| DECISION DELEGATED TO HEAD OF PLANNING |

| Application No: | H14-0200-23                                            | Applicant: | Mr T Rogers |
| Proposal:       | Alterations, extension and widening of existing access |            |             |
| Location:       | The Old Farmhouse Money Bridge Lane Pinchbeck          |            |             |

REAR ELEVATION

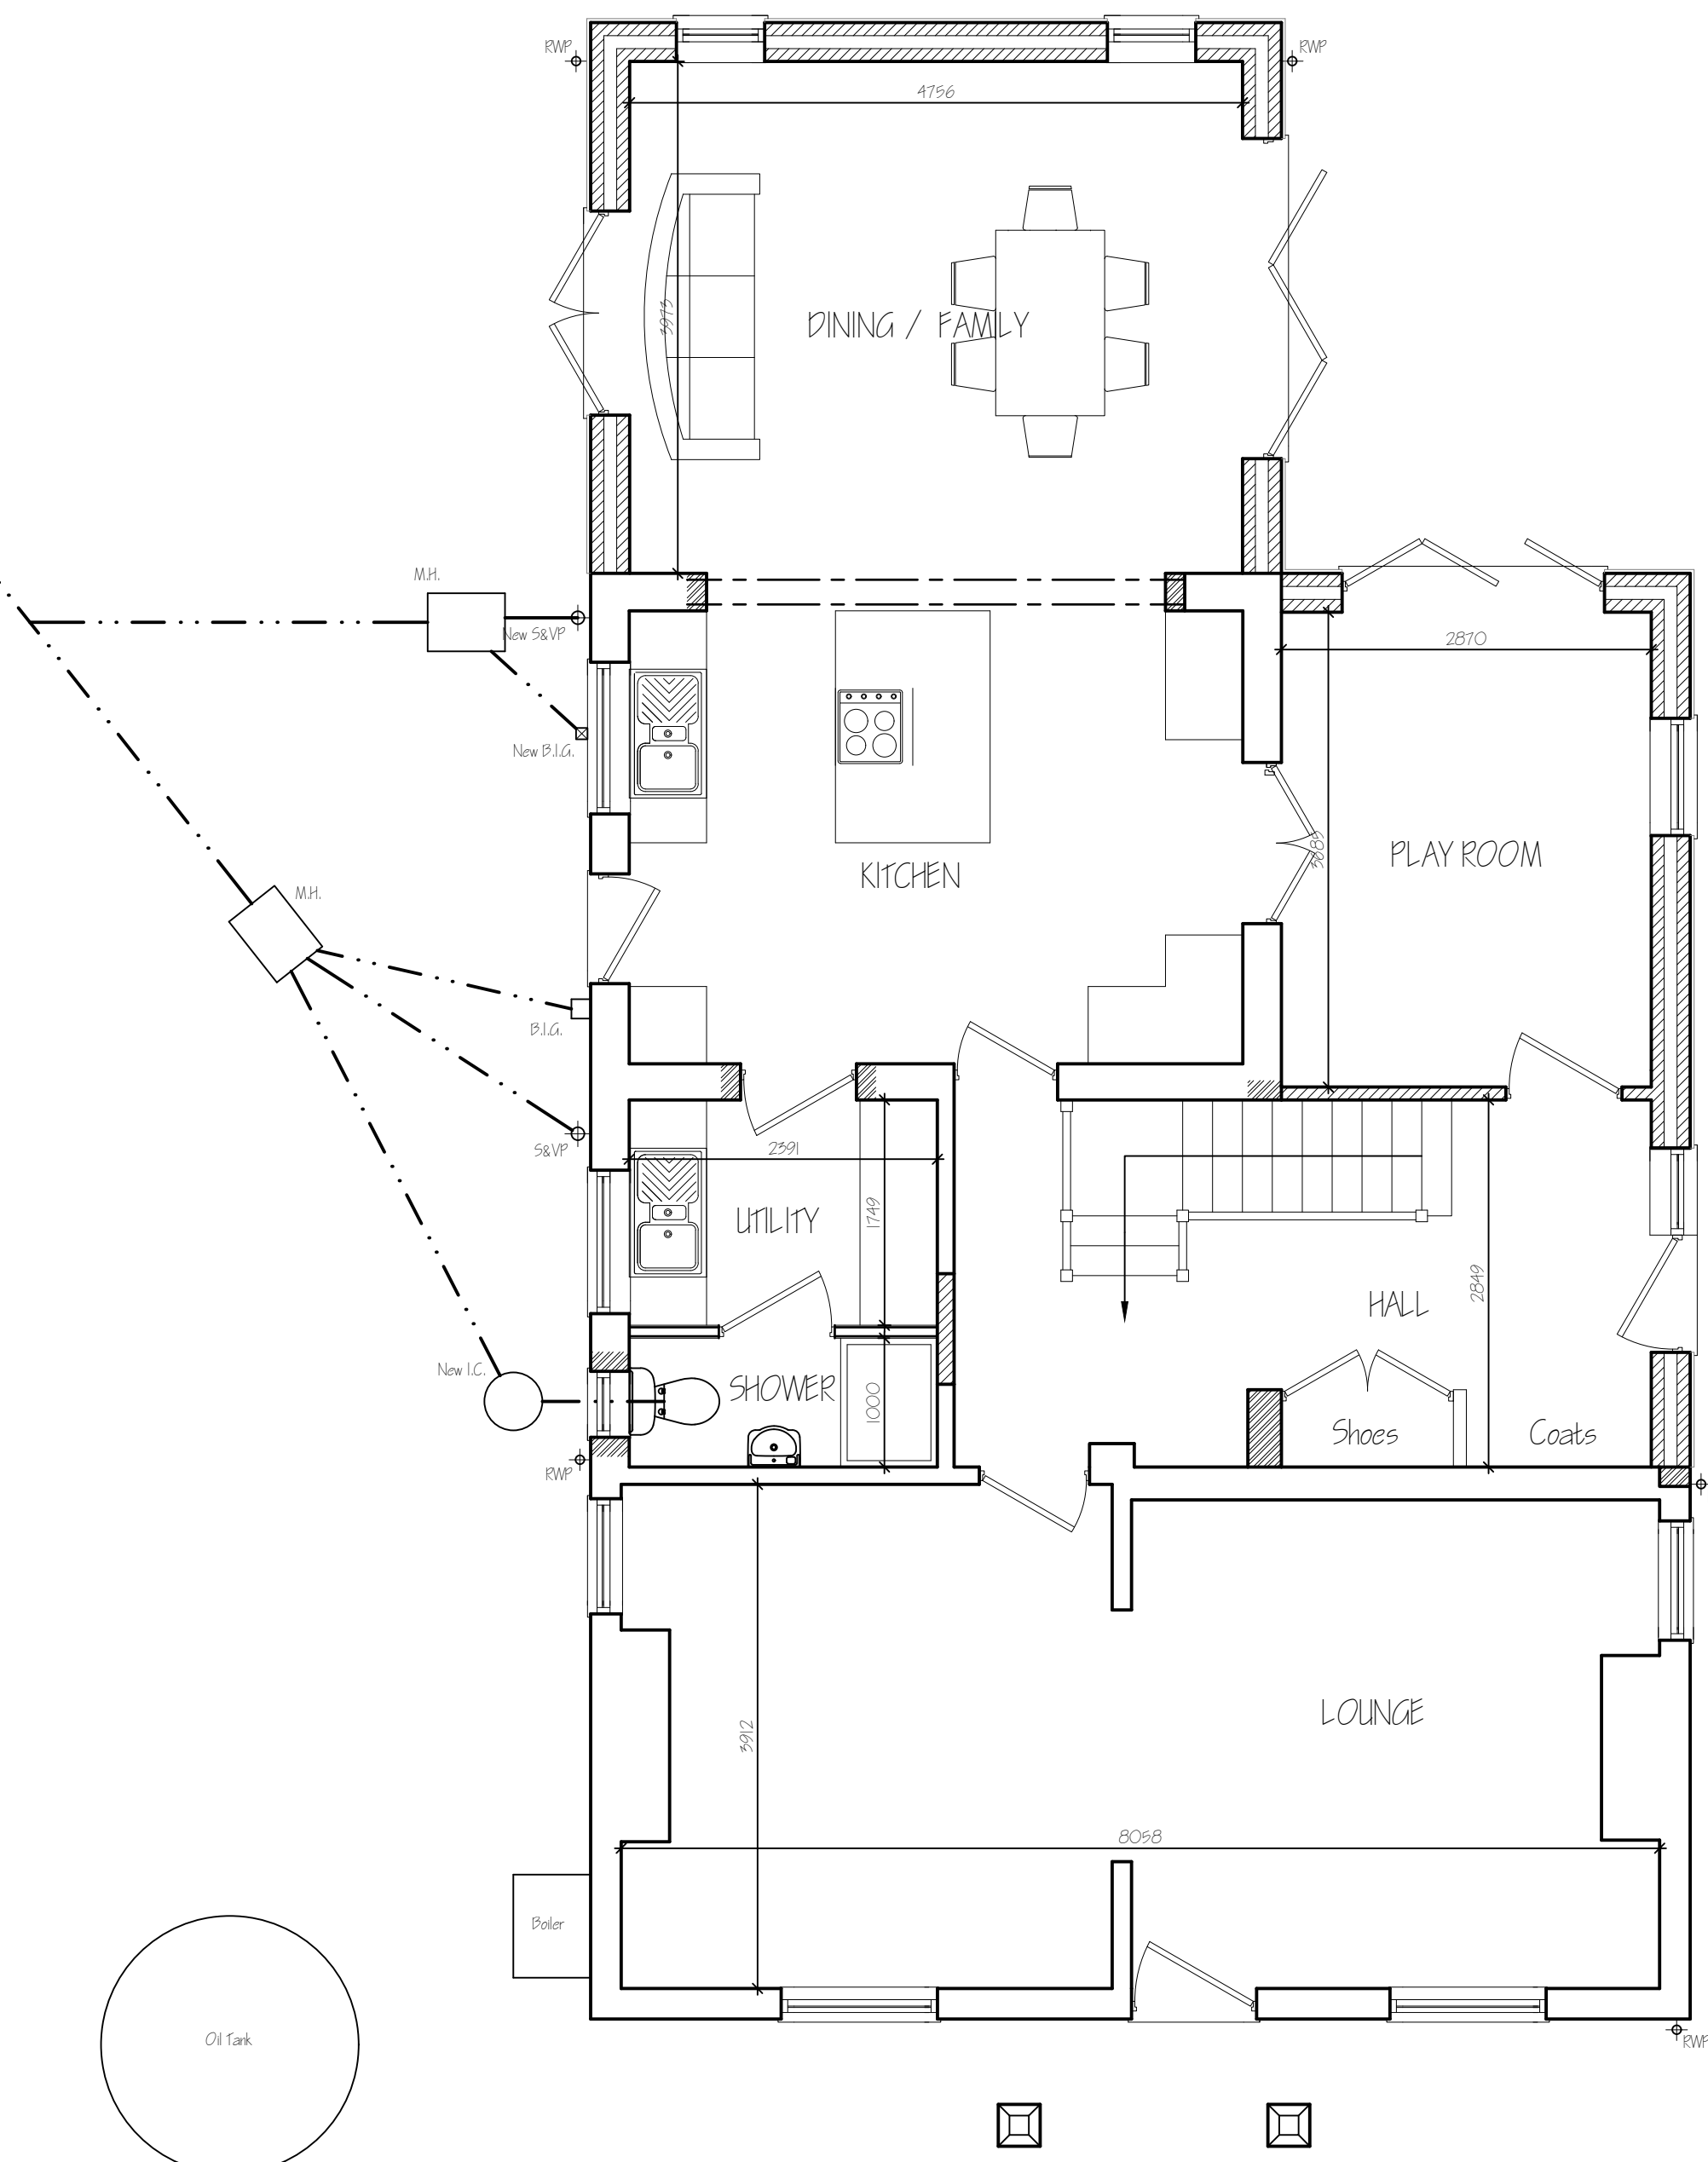
The proposal comprises of a two storey rear extension and first floor side extension. The two storey rear extension has been designed to consist of a dual pitched roof and would project from the rear elevation by 4.2m. The upper floor of the rear extension will include a Juliet balcony. The proposed first floor extension has also been designed to consist of a dual pitched roof and would be located above the existing flat roof element on the south elevation.

It is not considered that the proposal would overshadow or be overbearing to the neighbouring properties. The proposed windows include a Juliet balcony to the rear, and only an en-suit window on the north elevation facing the neighbouring dwelling and would therefore not create an overlooking impact.
